RE: 2802 Sioux St NW
Grading & Drainage Plan
Engineer's Stamp Date: 11/24/2025
Hydrology File: H13D126
Case # HYDR-2025-00422

Based upon the information provided in your submittal received 11/24/2025, the Grading & Drainage Plan **is not approved** for Building Permit. The following comments need to be addressed for approval of the above referenced project.

ENGINEER'S SEAL	TRACT 81A3 RIO GRANDE CONSERVANCY DISTRICT MAP 35 2802 SIOUX STREET	DRAWN BY DEM
		DATE 11-20-25
	DAVID SOULE P.E. #14522	
		SHEET # C1
		JOB #

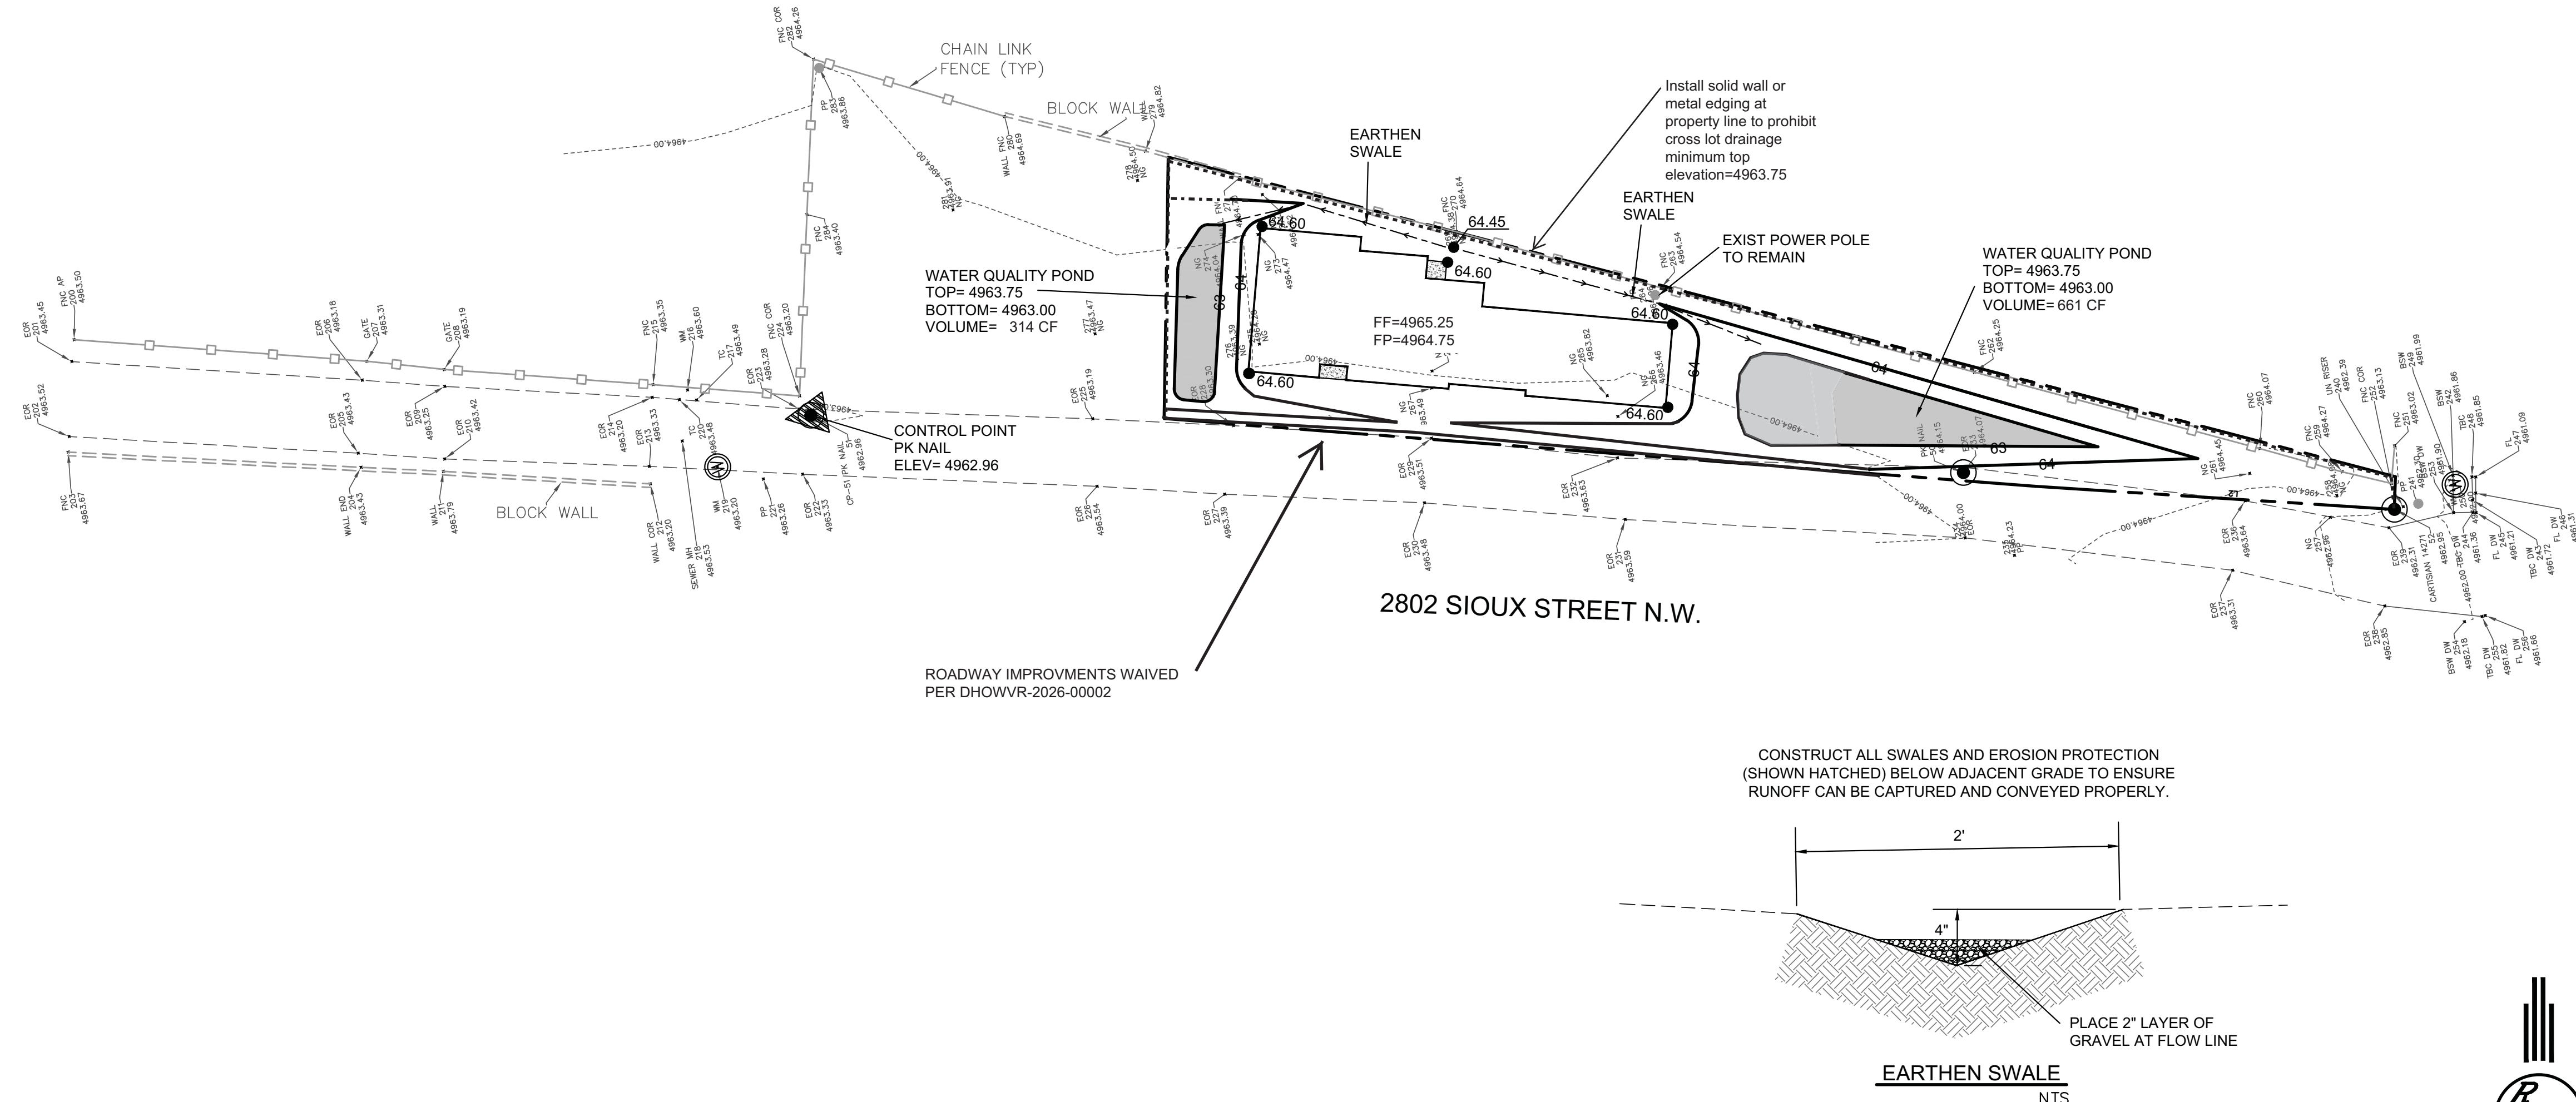
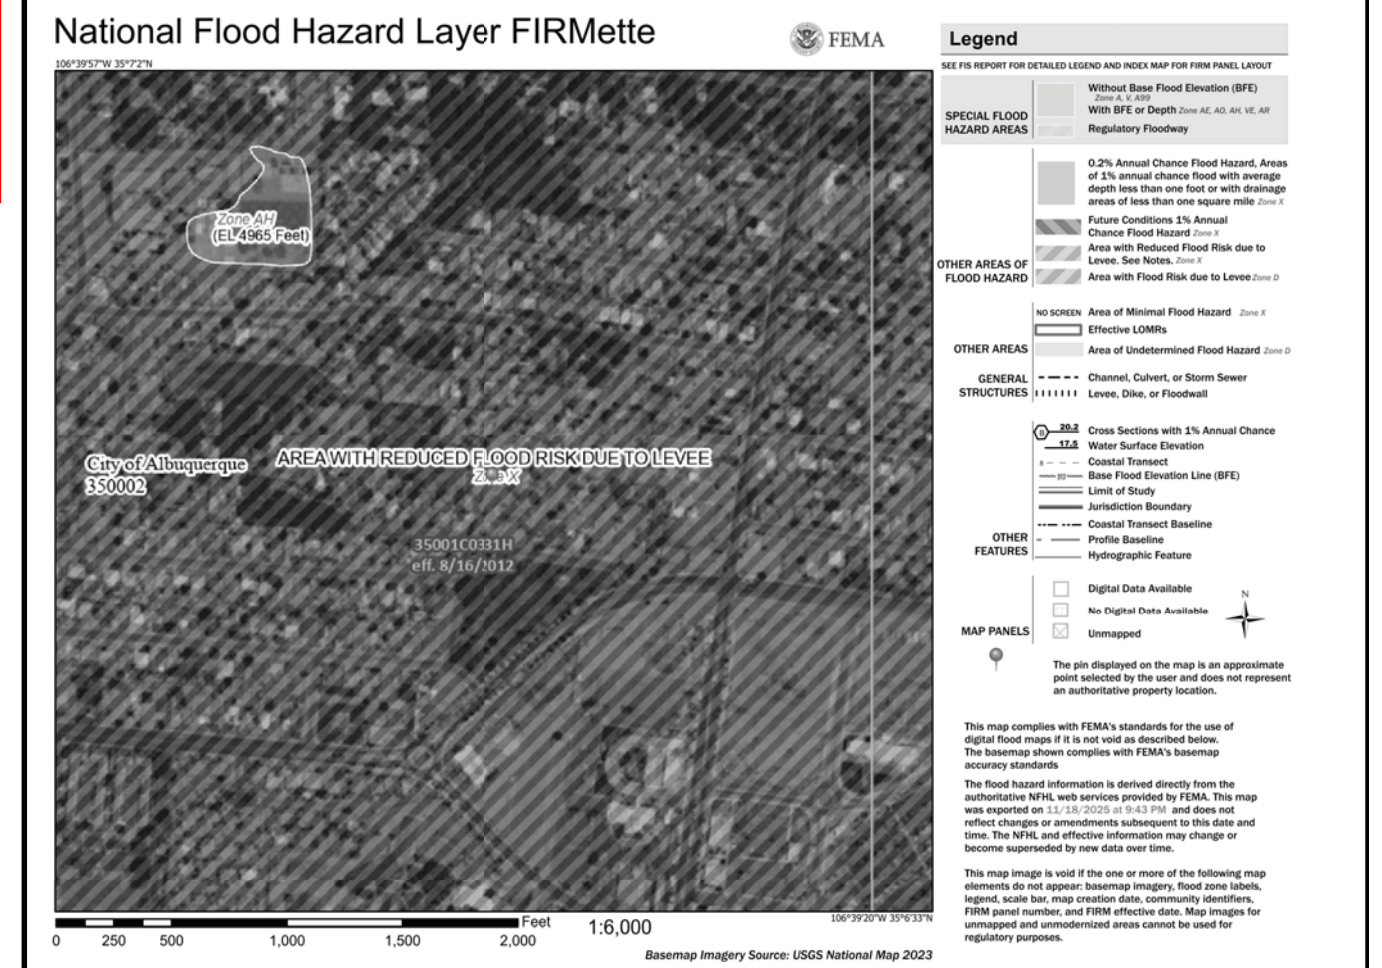
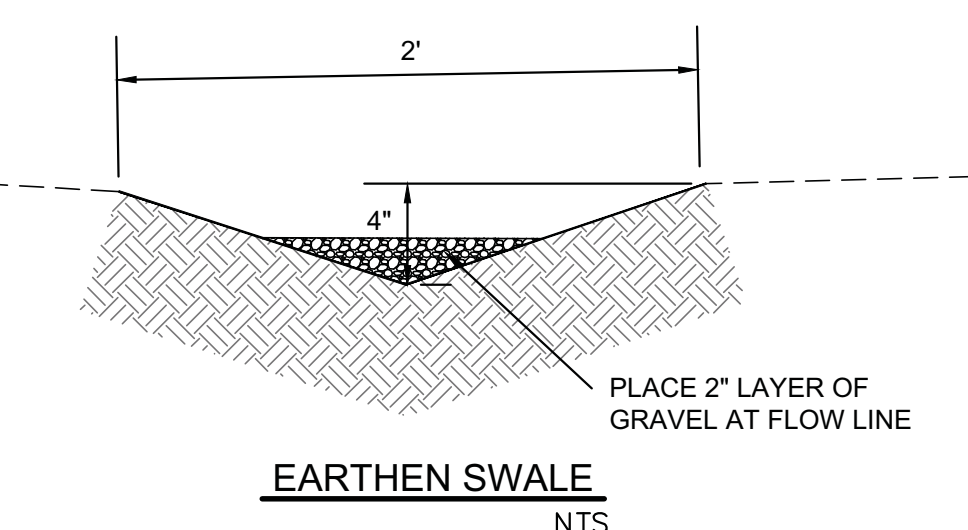
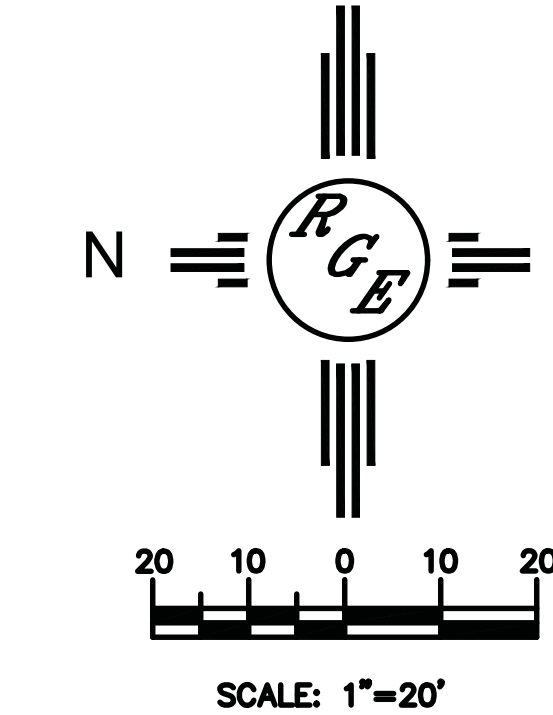
1. Per the IDO, the property owner of the property is responsible for building the adjacent half of Sioux Street to include curb & gutter, and sidewalk. The project will have to go to the Development Facilitation Team (DFT) for approval of the Infrastructure List.

2. Please show the curb & gutter, and sidewalk on the plans.
3. Stormwater discharges across the sidewalk are not allowed on collector roads and above; provide sidewalk culverts or drain lines through the curb.

4. Since this site is in the Valley region, please follow Article 6-5 Valley Drainage Criteria of the DPM. The following conditions must be applied to the site:

- a. Pad elevation shall be a minimum of one (1) foot above the 100 year 10-day stormwater surface elevation.
 - b. A permanent perimeter wall or barrier around the development is required to contain the 100 year 24 hour storm developed runoff.

5. Please provide the FIRM Map and floodplain note with effective date.
